TOWN AND COUNTRY PLANNING ACT 1990

PRIOR NOTIFICATION

Reference: H20-0713-21 **Date of Decision:** 6th October 2021
Applicant: Mr & Mrs Githiri
Chestnut House
Broadgate
Sutton St James
Spalding
PE12 0HD
Location: Adj. Chestnut House Broadgate Sutton St James Spalding
Description: Change of use of barn to residential dwelling using existing access

PROPOSED
FLOOR PLANS & ELEVATIONS
SITE PLAN

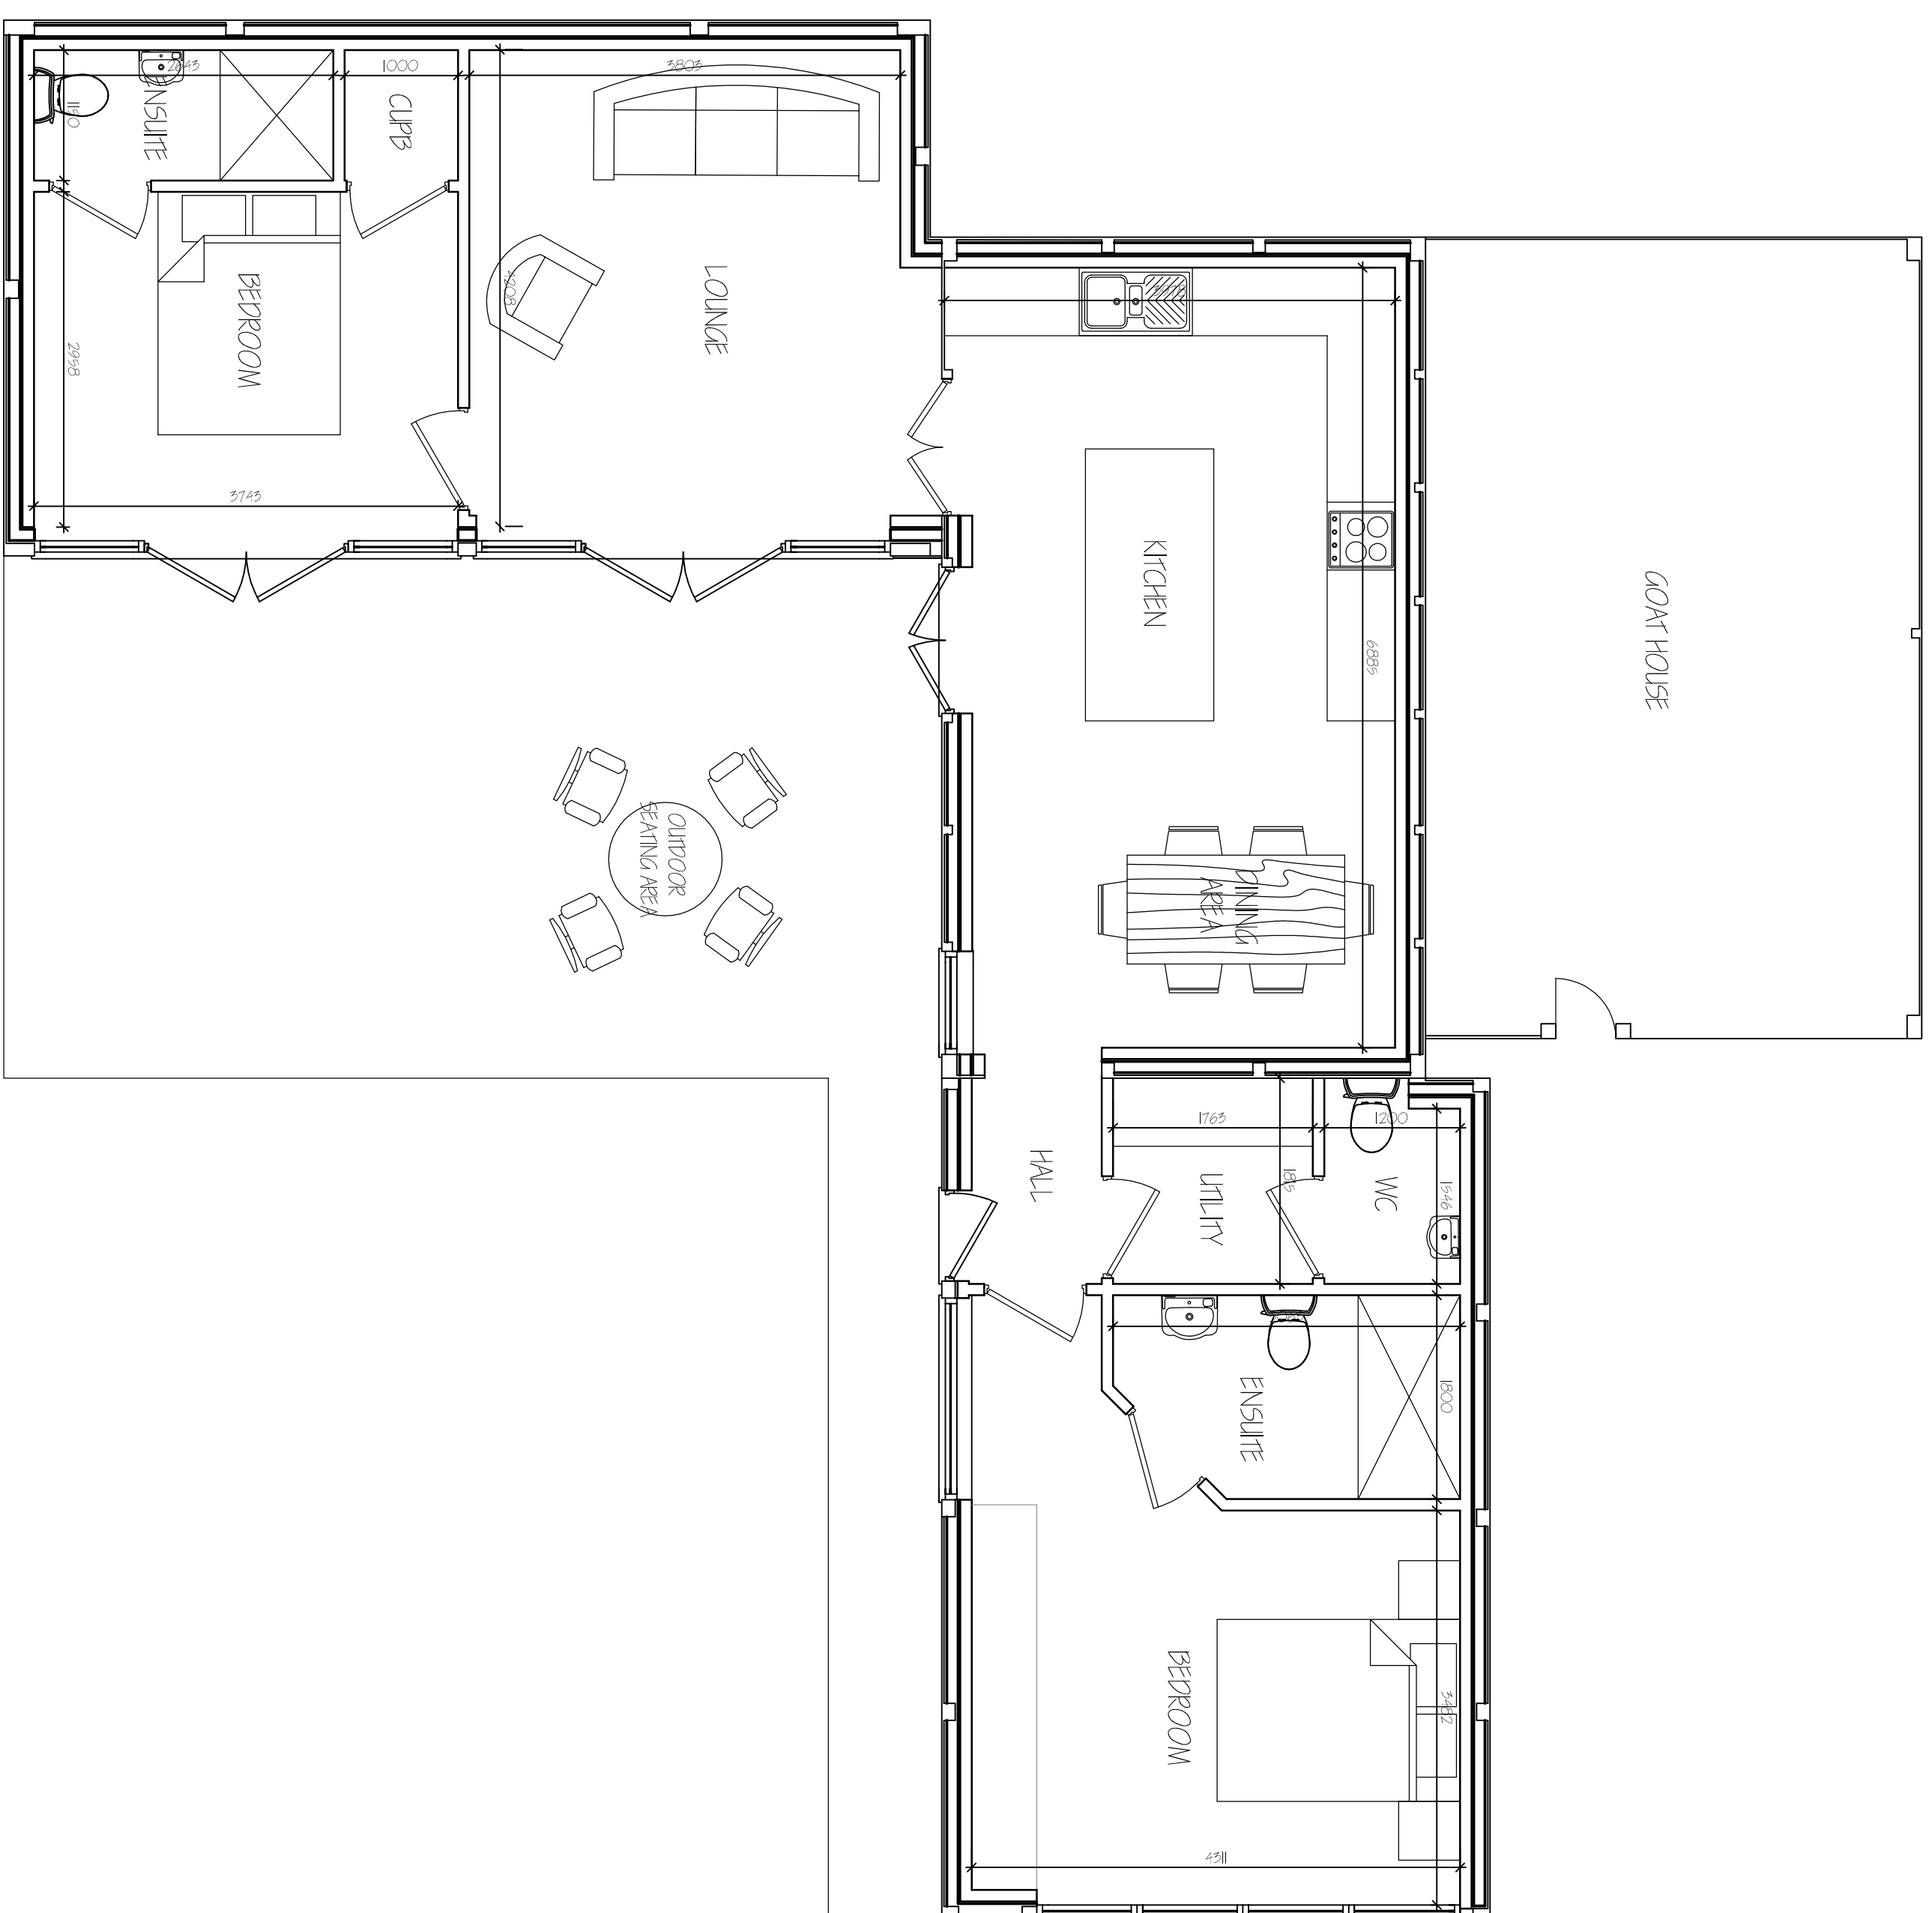
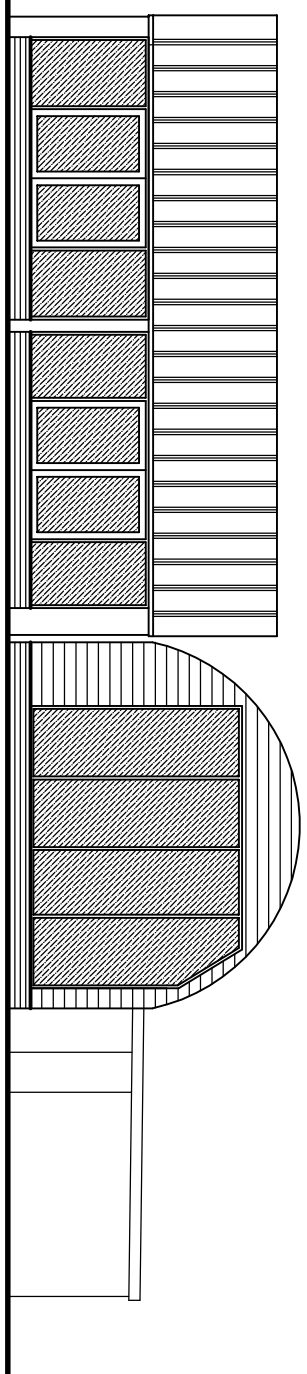
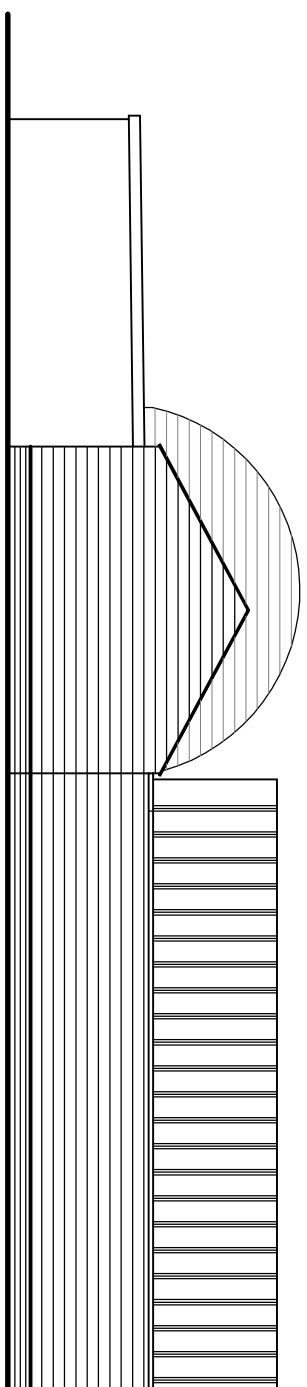
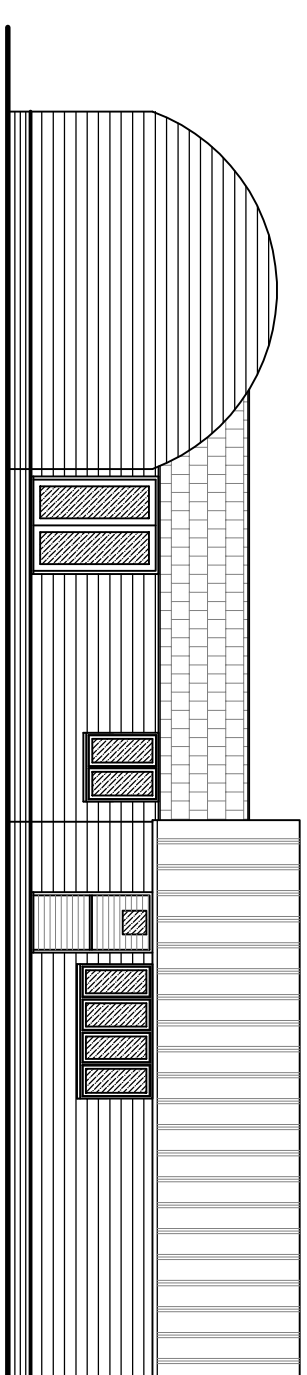
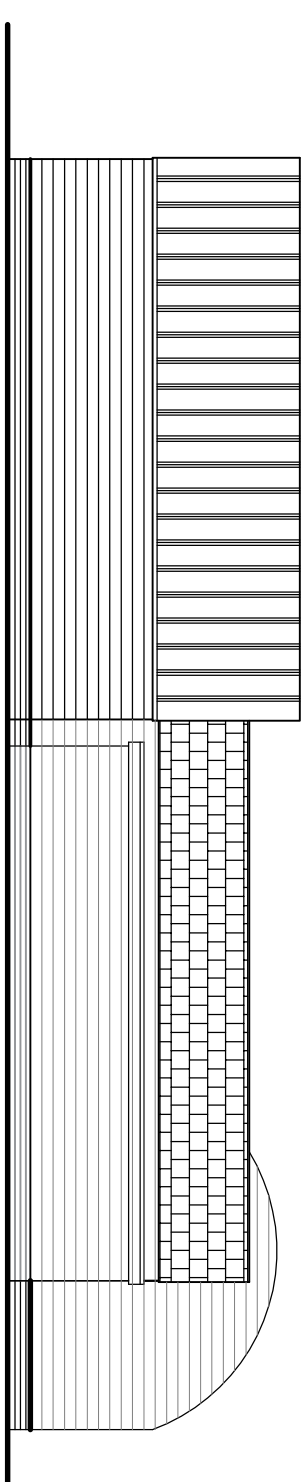
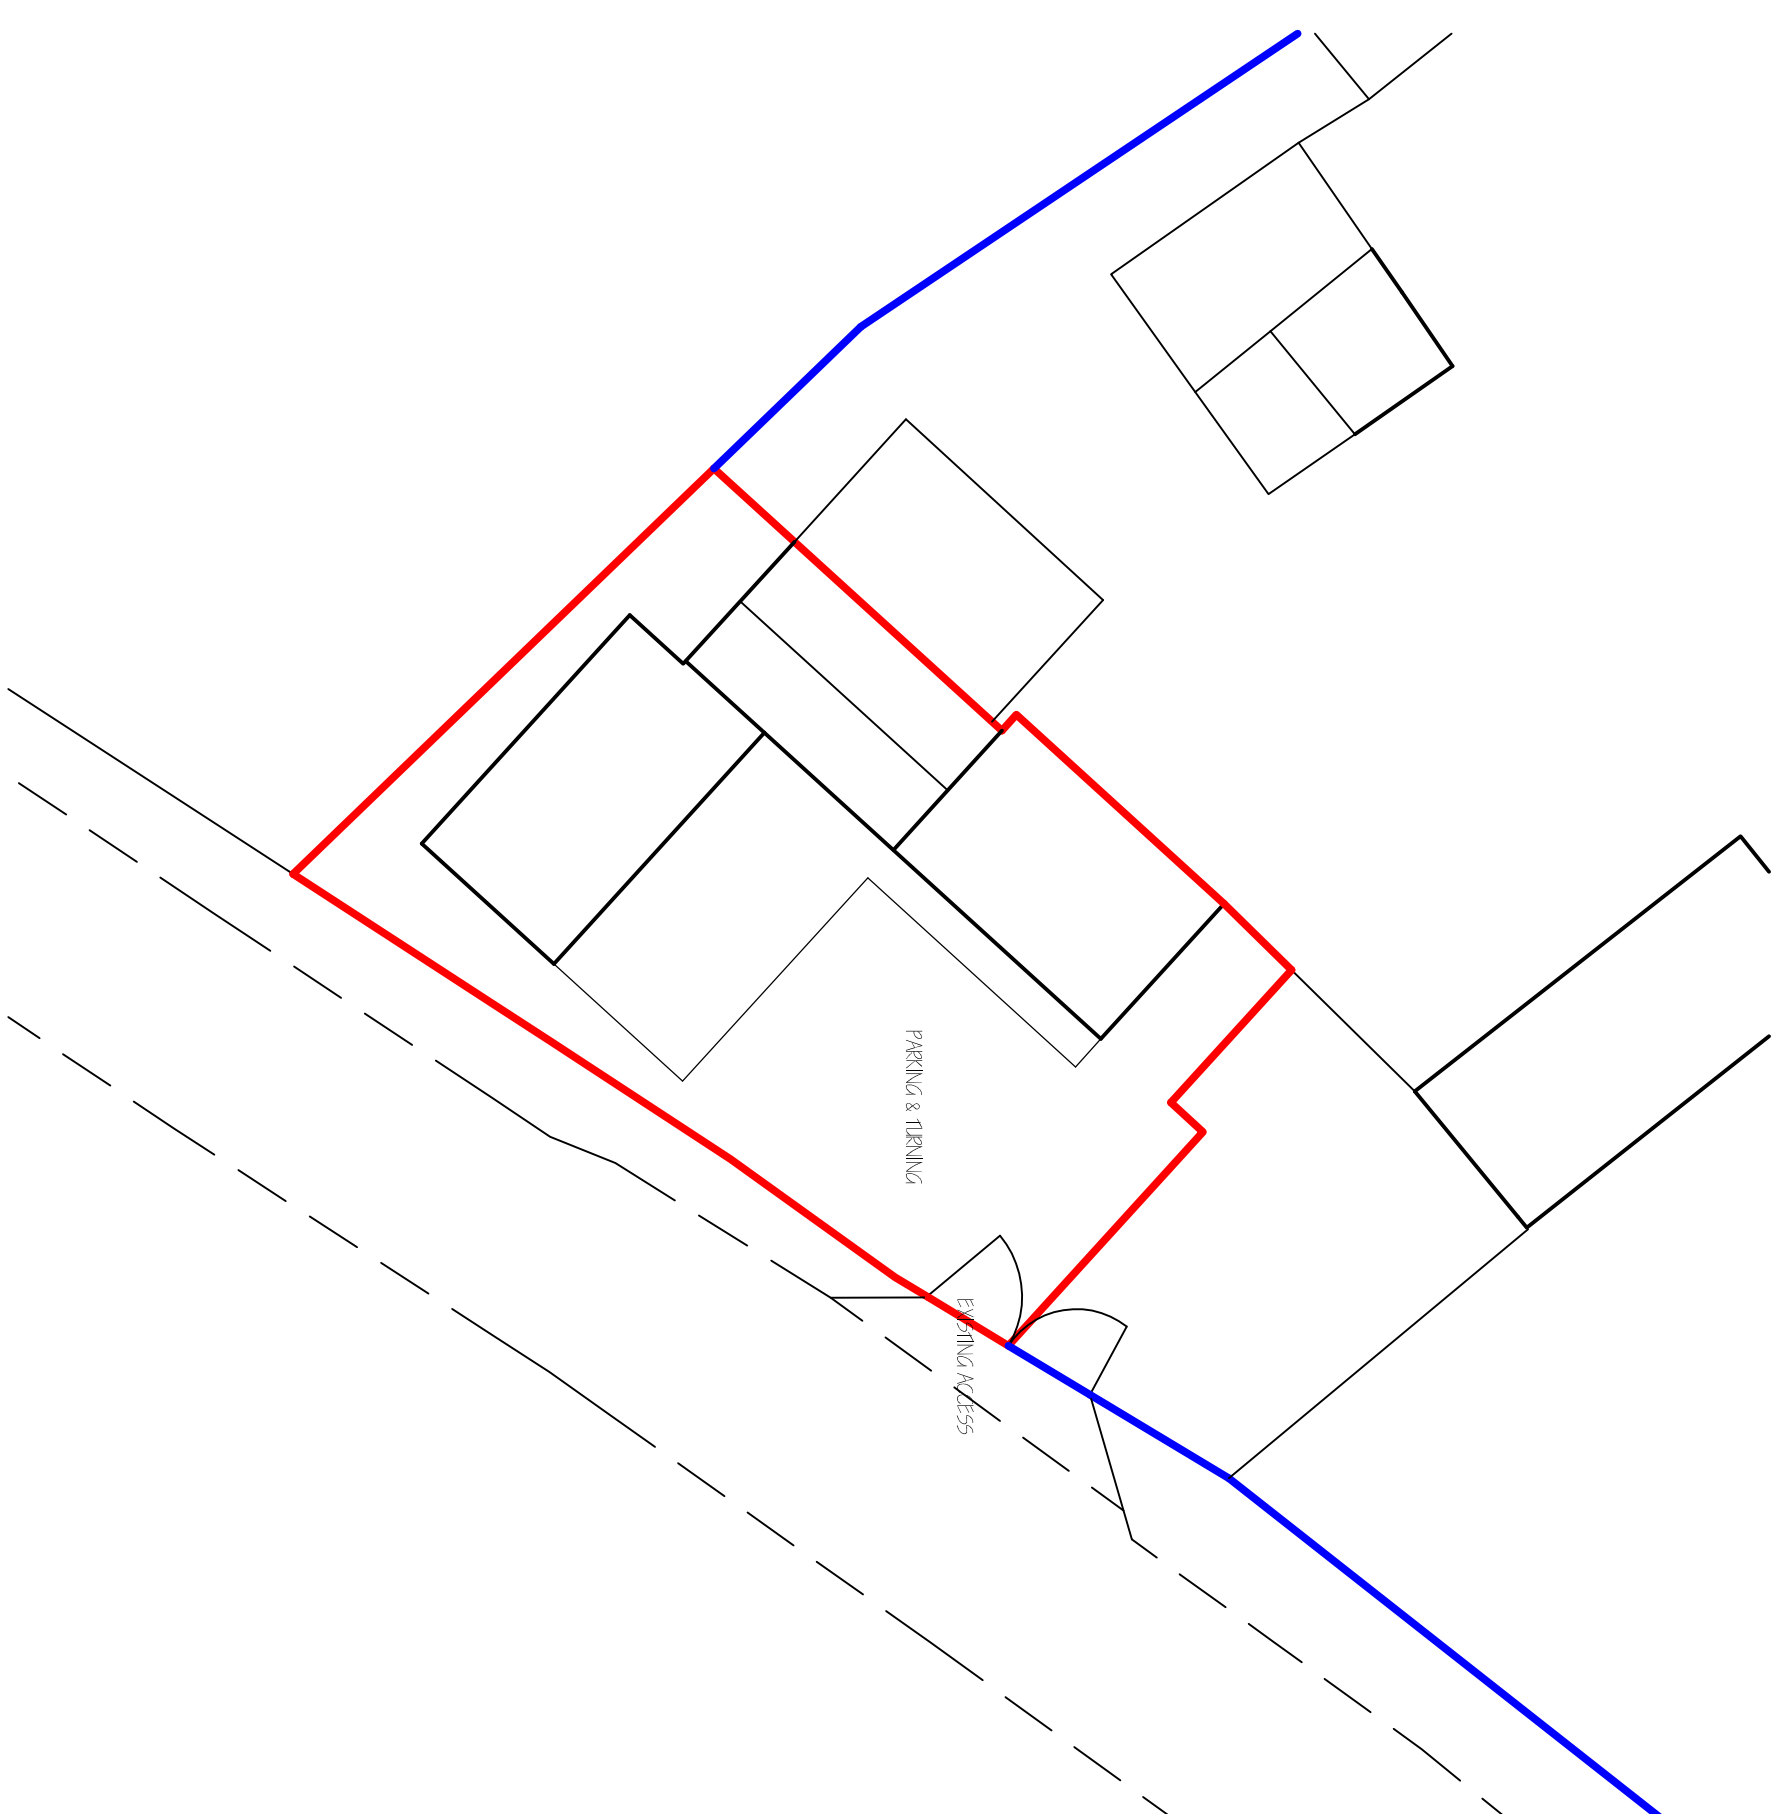
- 1 It has not been satisfactorily demonstrated that the proposal would not involve new structural elements. As such, it is considered that the proposed works fail to satisfy the requirements of paragraph Q.1(i). As a consequence, the proposal is not permitted development under Class Q(b) of Part 3 of Schedule 2 of The Town & Country Planning (General Permitted Development) Order, 2015.

Moreover, an Ash (*Fraxinus excelsior*) tree, which is the subject of Sutton St James Tree Preservation Order No. 4, 1991, is situated immediately to the south-west of the buildings. The development would, if permitted, compromise the tree and result in pressure to remove it, thereby prejudicing its continued existence, to the detriment of the visual amenities of the rural locality.
